**APPLICATION BY HIGHWAYS ENGLAND FOR AN ORDER GRANTING  
DEVELOPMENT CONSENT FOR THE A428 BLACK CAT TO CAXTON GIBBET  
IMPROVEMENTS**

**APPLICATION REF: TR010044**

**COMMENTS OF THE HISTORIC BUILDINGS AND MONUMENTS COMMISSION  
FOR ENGLAND (HISTORIC ENGLAND)**

Figure 2-4 – Potential Impact of Option 1c on Brook Cottages

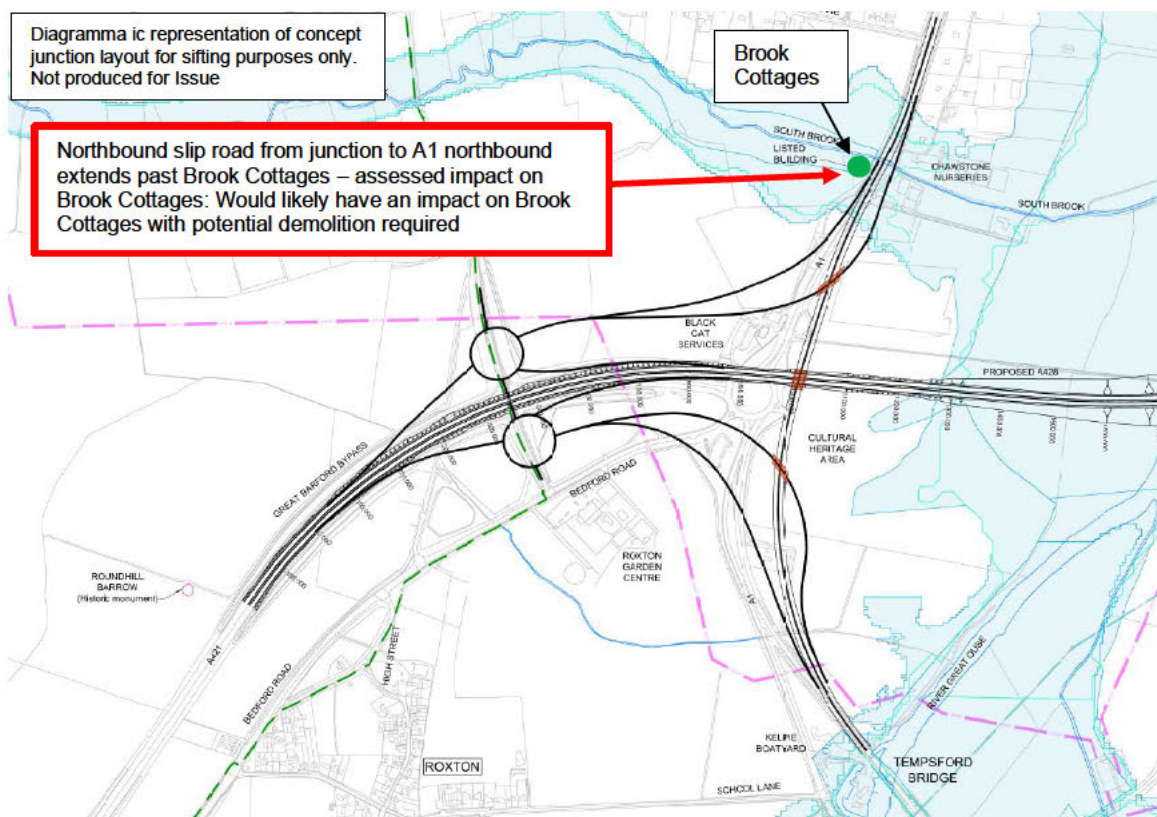
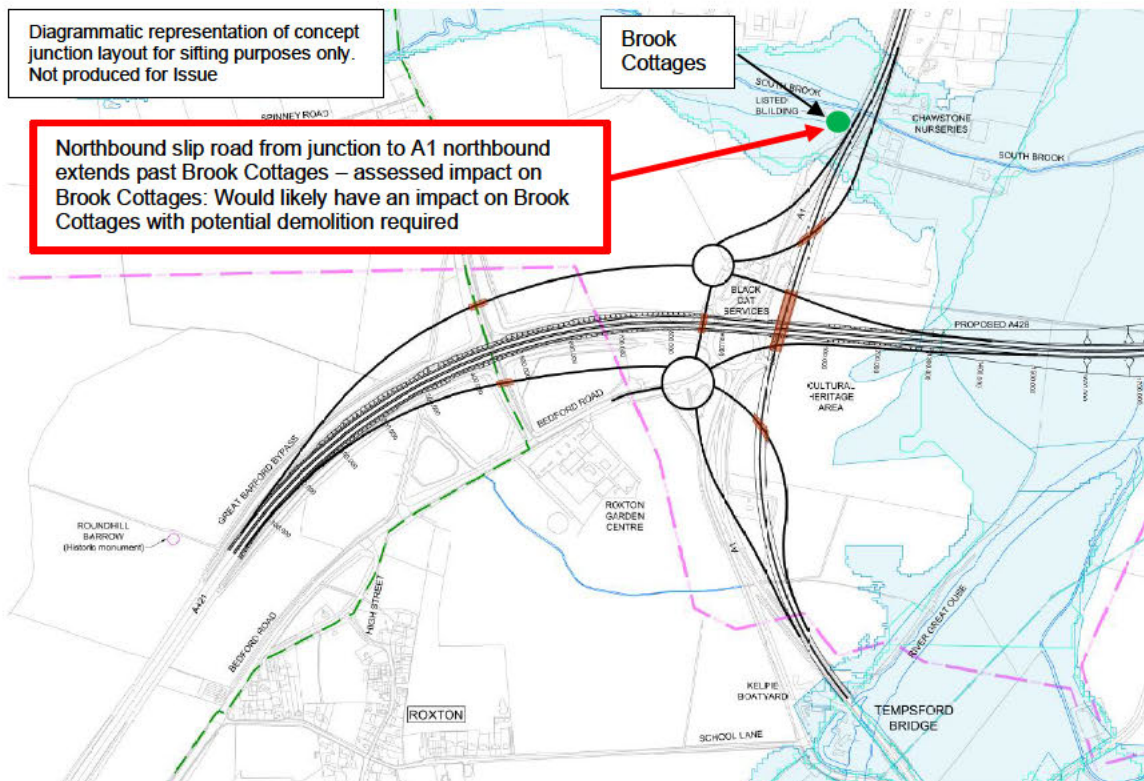
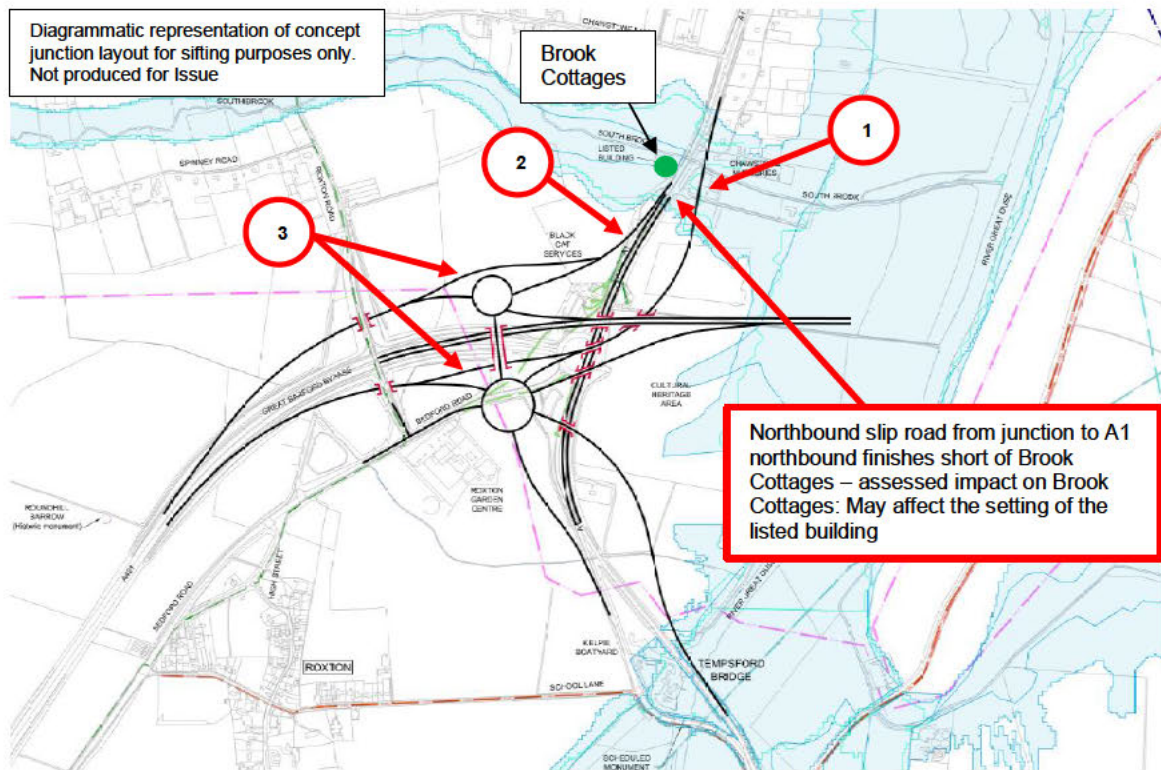
*We reiterated the view (set out in our Written Representations) that the applicant's approach to dismantling and reconstructing Brook Cottages appears to embody certain assumptions about the impracticality of retaining some elements of the historic fabric and the primary importance of dismantling and retaining structural timber members. It is our view but there is no evidence to suggest this is the only method of dismantling and relocation possible and that exploring a range of*

| <p>Q3.12.2<br/>.3</p>                        | <p>Applicant<br/><b>Historic England</b><br/>Bedford<br/>Borough<br/>Council</p> | <p><b>Black Cat Junction Options</b></p> <p>a) Applicant, in the Black Cat Options overview report [REP4-032, Appendix C, row 19], the RAG table assumptions relating to “Sites of Archaeological importance / listed buildings disturbed by option” are medium or low. Explain how the ExA can have confidence in this approach given that despite these assumptions, the Proposed Development requires the demolition of a Grade II listed building? HistE and BBC may comment.</p> <p><i>Historic England response: We have no comment to make on this matter.</i></p> <p>b) Applicant, evidence what specific heritage expertise was used to inform the sifting and selection process? Provide evidence. HistE and BBC may comment.</p> <p><i>Historic England response: We have no comment to make on this matter.</i></p> <p>g) HistE, with reference to your comments at ISH3 [EV-045] and your response to the ExA’s WQ2s [REP4-069 Q2.12.2.1] would you like to elaborate on your position in the SOCG regarding the (exceptional) justification for the demolition of Brook Cottages [REP6-016]</p> <p><i>Historic England response: It remains our position that we are not able to comment on the Black Cat junction options and the preferred junction design as these discuss issues of highways engineering in which we do not have expertise. We are therefore unable to comment on the justification for this preferred design and the necessity of demolishing the cottages to implement it. The NPPF asks for the public benefits of the scheme to be weighed against the loss of the listed building, but this is a balance it is for the determining authority to make.</i></p> |
